Development Facilitation Team (DFT) – Review Comments

Project No: PR-2022-006847 Date: 05/08/2024 Agenda Item: #2 Zone Atlas Page: G-12

Request: Approval of Minor – Preliminary/Final Plat, Vacation of Public Right and Sidewalk Waiver

Location: 2818 Campbell Road NW between Campbell Road NW and Mancha Drive NW

EXISTING BOUNDARY AND VACATIONS

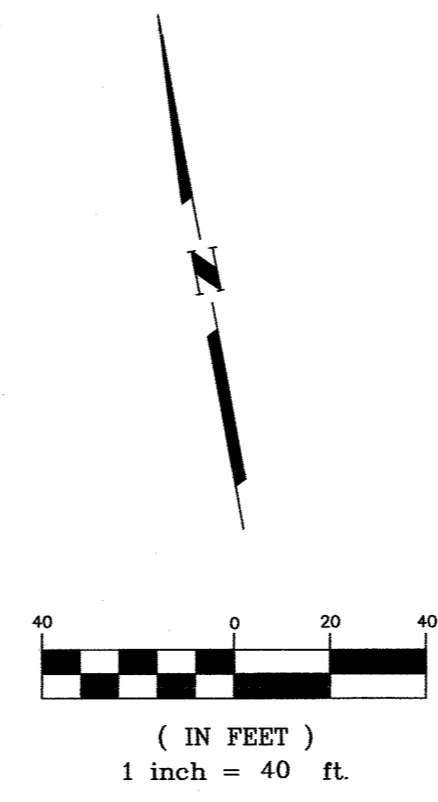
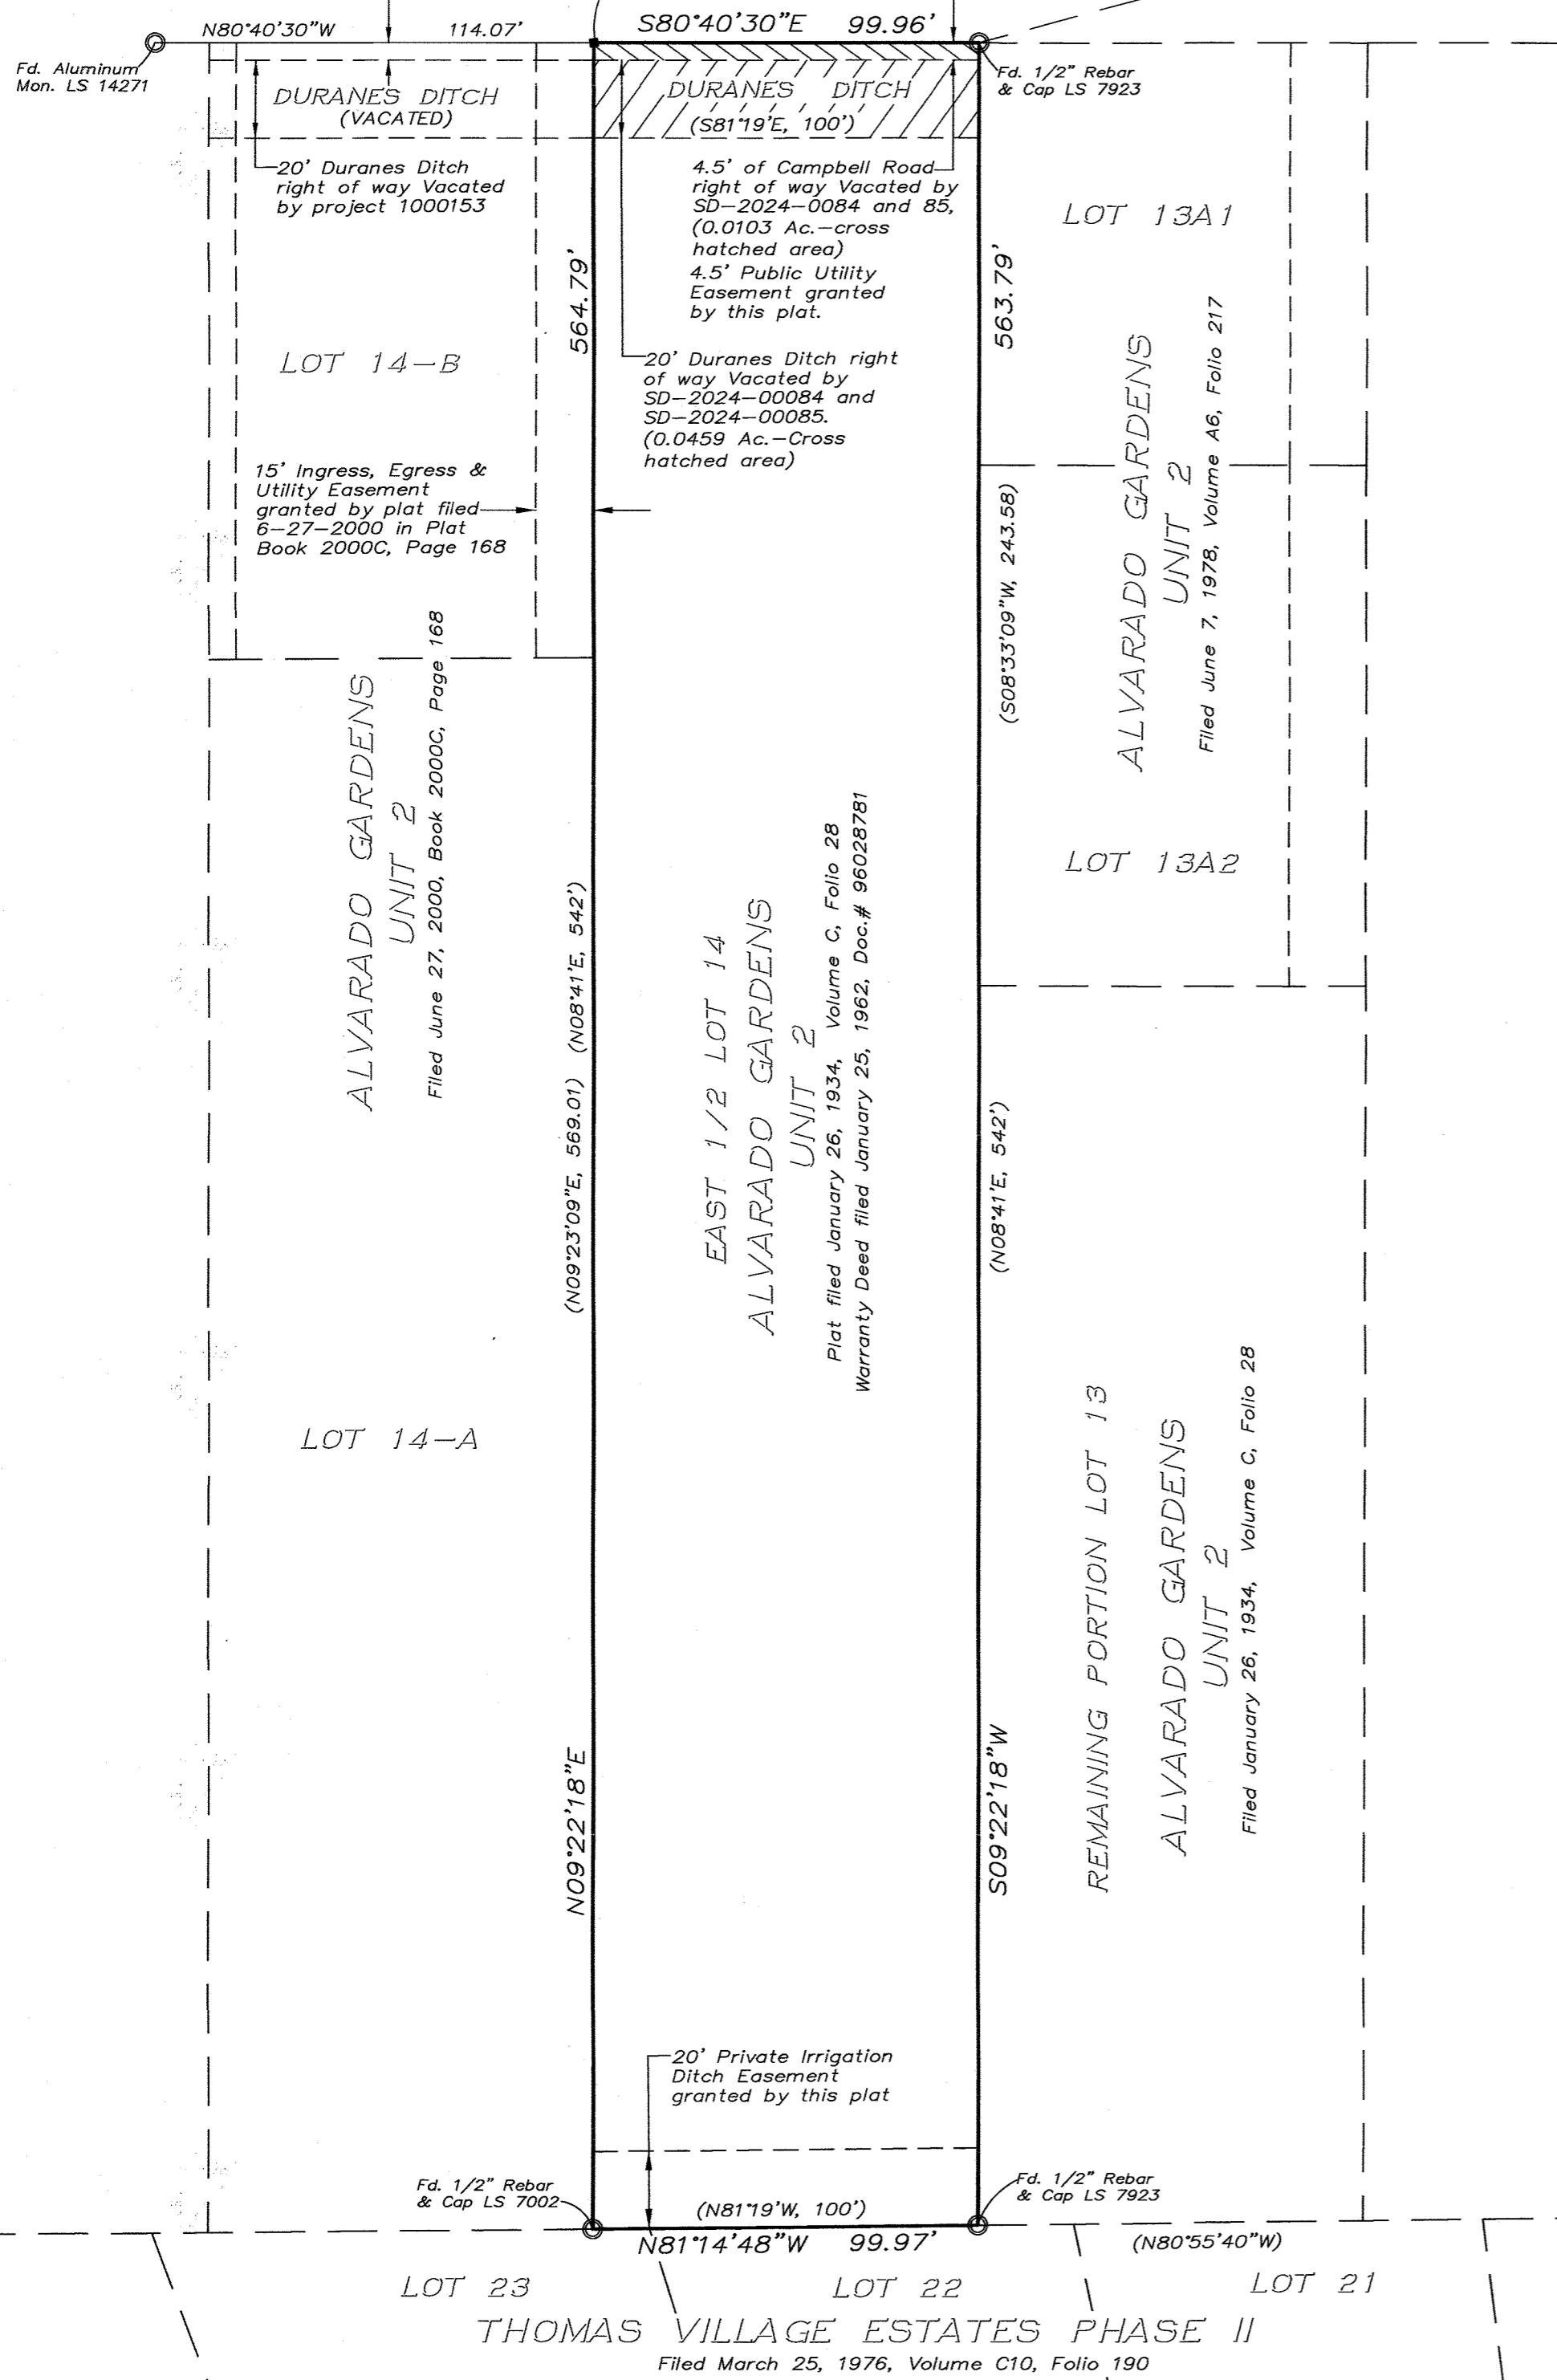
- Project and application numbers must be added to the Plat sheet.
- For the Sidewalk Waiver, the Applicant must justify the Waiver per 6-6(P)(3) of the IDO, and adequate justification was not provided in the justification letter; the justification letter addresses 6-6(P)(3)(a)(1)(c) and 6-6(P)(3)(a)(10). However, the following additional criteria must be addressed in the justification letter:

- The DXF File must be approved by the AGIS office prior to final sign-off of the Plat.
- Per 6-6(K)(2)(g) of the IDO, the Sidewalk Waiver and two Vacations of Public Right-of-Ways and their DHO dates of approval must be noted on the Plat prior to final sign-off of the Plat.

- Per 6-6(K)(2)(K) of the IDO, the date of the DHO approval shall be recorded on the Plat, therefore requiring the date of DHO approval be added to the Plat prior to final sign-off of the Plat.

NEW LOTS AND EASEMENT

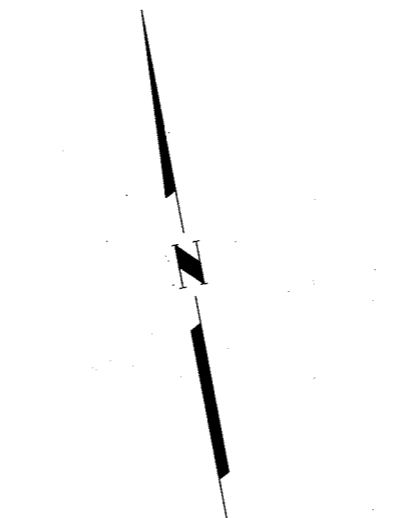
1. Property is zoned R-A (Rural and Agricultural Zone), and must meet all Dimensional standards of IDO section 5-1 and Table 5-1-1.
2. Must meet all standards in IDO section 5-4 Subdivision of Land, and, more specifically, 5-4(C) Zoning Compliance and 5-4(F) Lot Dimensions.
3. Subdivision/re-plat of property cannot increase any existing nonconformity or create a new nonconformity.
4. Future development must meet all applicable standards and provisions of the IDO, DPM, and any other City regulations.
5. Property is in an Area of Consistency, and must meet all requirements as per IDO section 5-1(C)(2) regarding size of lot(s). Calculations of allowed lot sizes for this lot are a minimum of 0.4781 acre and maximum of 0.7969 acre.

Lot 14-A-1 = 0.4830 acre = within the minimum allowed lot size of 0.4781 acre.

Lot 14-B-1 = 0.8119 acre = exceeds the maximum allowed lot size of 0.7969 acre.

You will need to adjust the sizes of the lots, obtain a variance to the required size, or submit a Deviation Application with your Preliminary/Final Plat application. See the attached map and calculations on the next page.
